Job No. 177316

Re: Response to El Paso County, El Paso County Health, and CGS Review Comments
Halleluiah TI
EPC Schedule No. 4208000013
El Paso County, Colorado

SOILS AND GEOLOGY STUDY

**Jeanette Mose Subdivision
Halleluiah Trail
EPC Schedule No. 4208000013
El Paso County, Colorado**

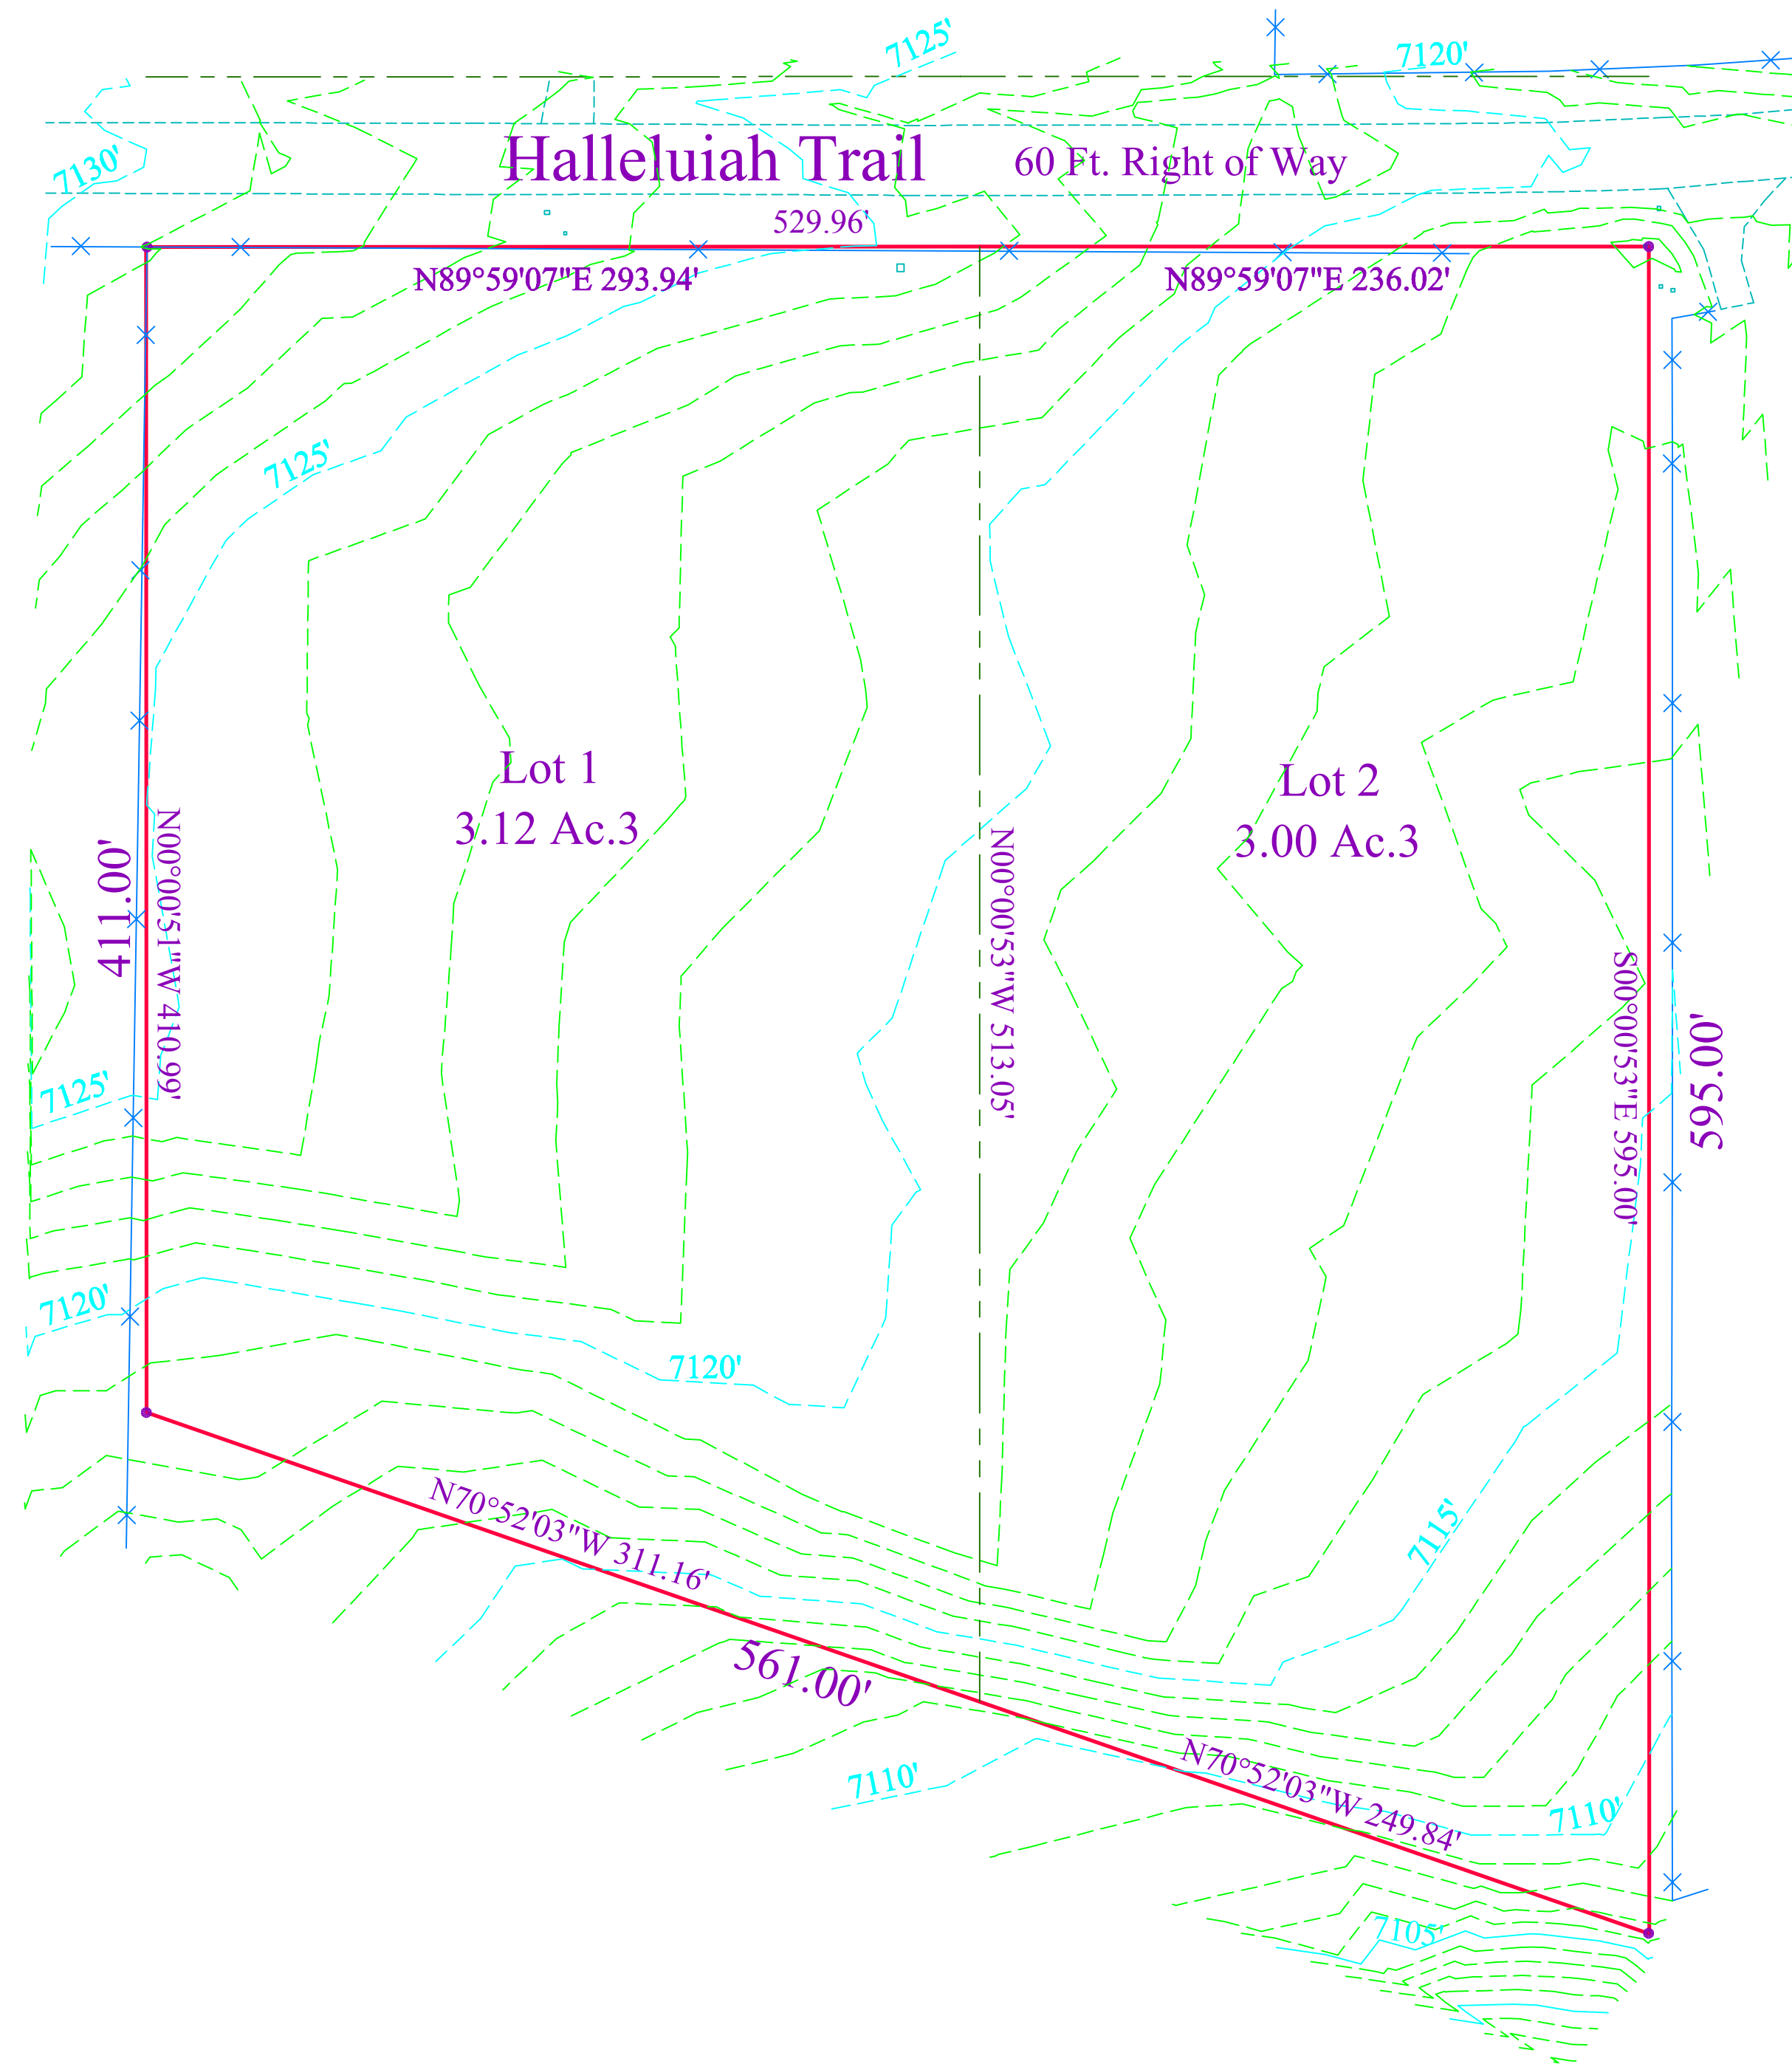
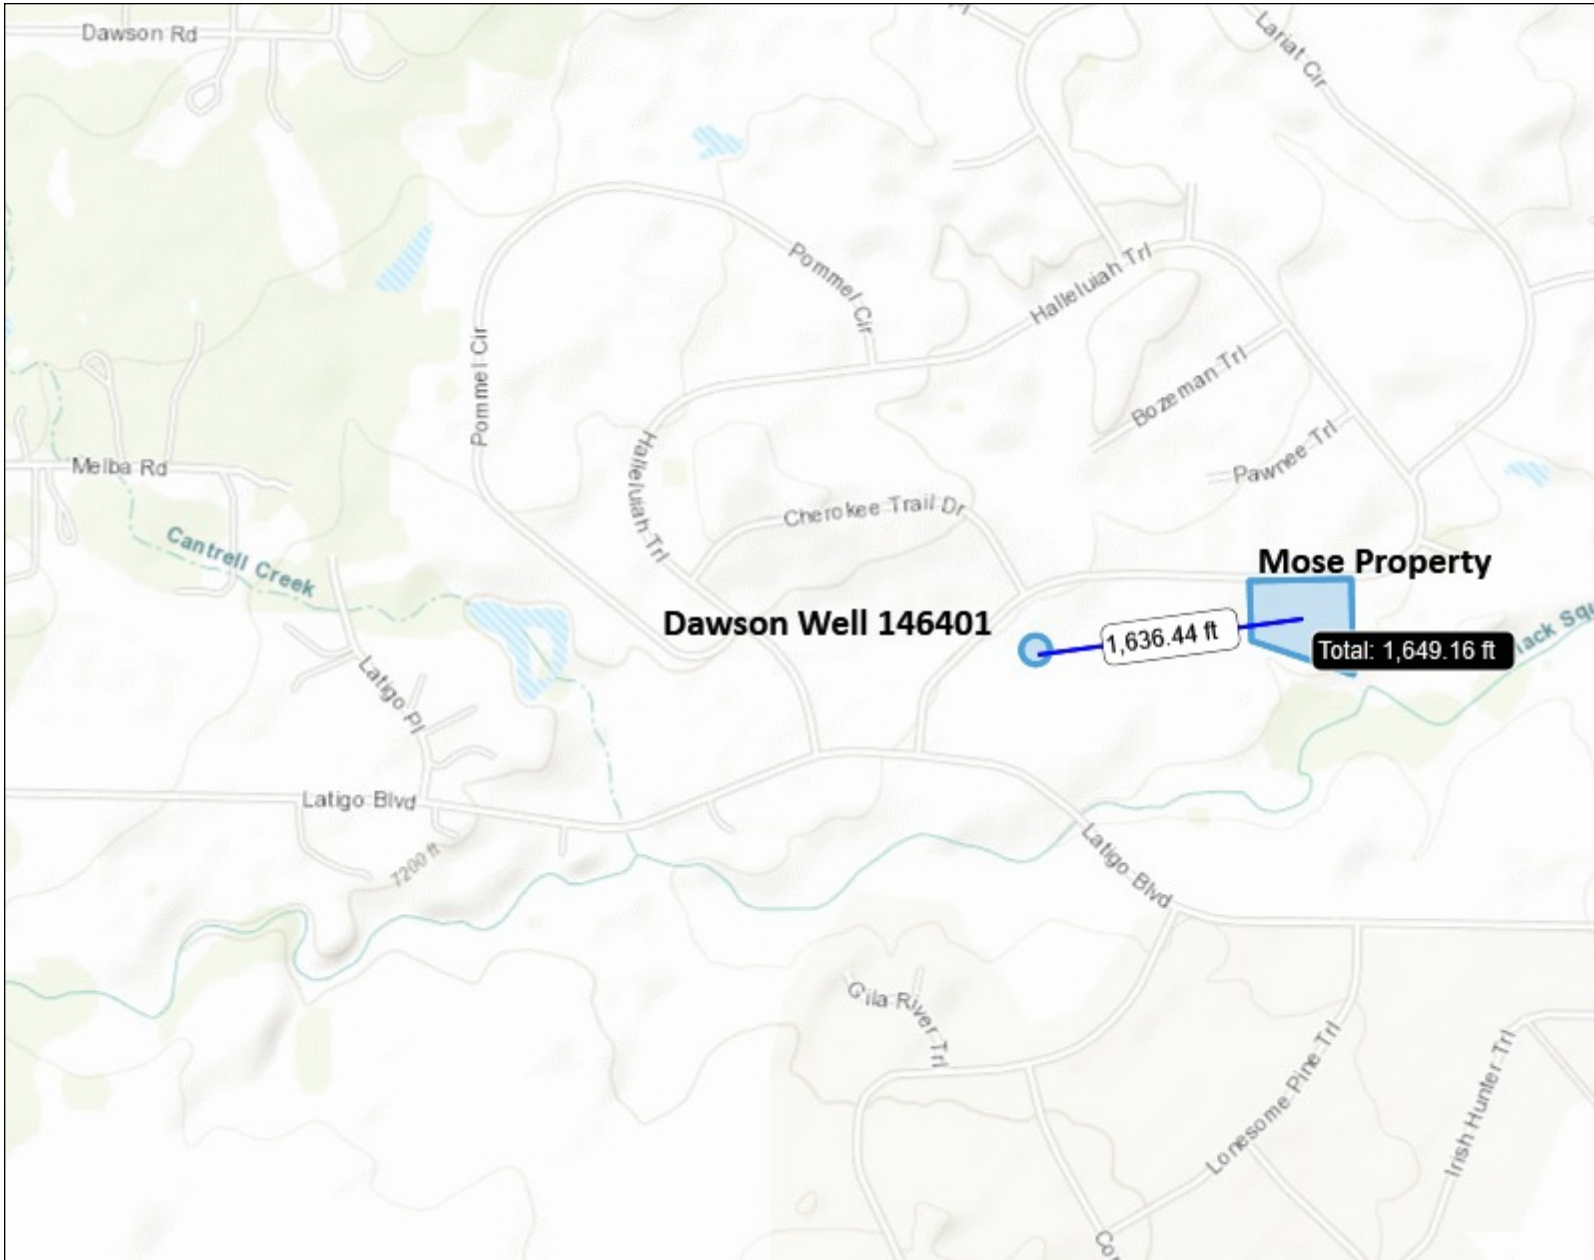
Hazard areas, per CGS
comments, are still not shown
as no-build areas on the plat.
Please revise

Hazard areas that cannot be mitigated must be shown on plat as no-build areas. Please provide graphic indicating hazard areas within site.

This information seems to conflict plat note #12. The OWTS Report must show proposed septic drain field locations for each lot. Report as submitted still only addresses lot 1.

Plat note 11 should identify RMG and Geoquest and the dates their reports were completed. Plat note 4 and 12 should state that the septic systems must be engineered systems due to shallow bedrock as stated by GeoQuest."

The review comment in question (originally commented on the Geoquest *Soils Report* for Lot 1, clip pasted below) indicates that "*Hazard areas **that cannot be mitigated** must be shown on plat as no-build areas*" (text bolded for emphasis). As noted in our *Soils and Geology Study*, the hazards encountered on this site can be mitigated by implementing appropriate planning, engineering, and local construction practices. As our investigation didn't identify any hazards that cannot be mitigated, there are no "no-build" areas to map on the plat.

Note 12 on the revised plat includes a statement that, “*Basements are not allowed in this subdivision due to shallow groundwater unless groundwater monitoring (through the annual seasonal fluctuations) prior to construction.*”

Plat notes 4, 11, and 12 have been revised accordingly.
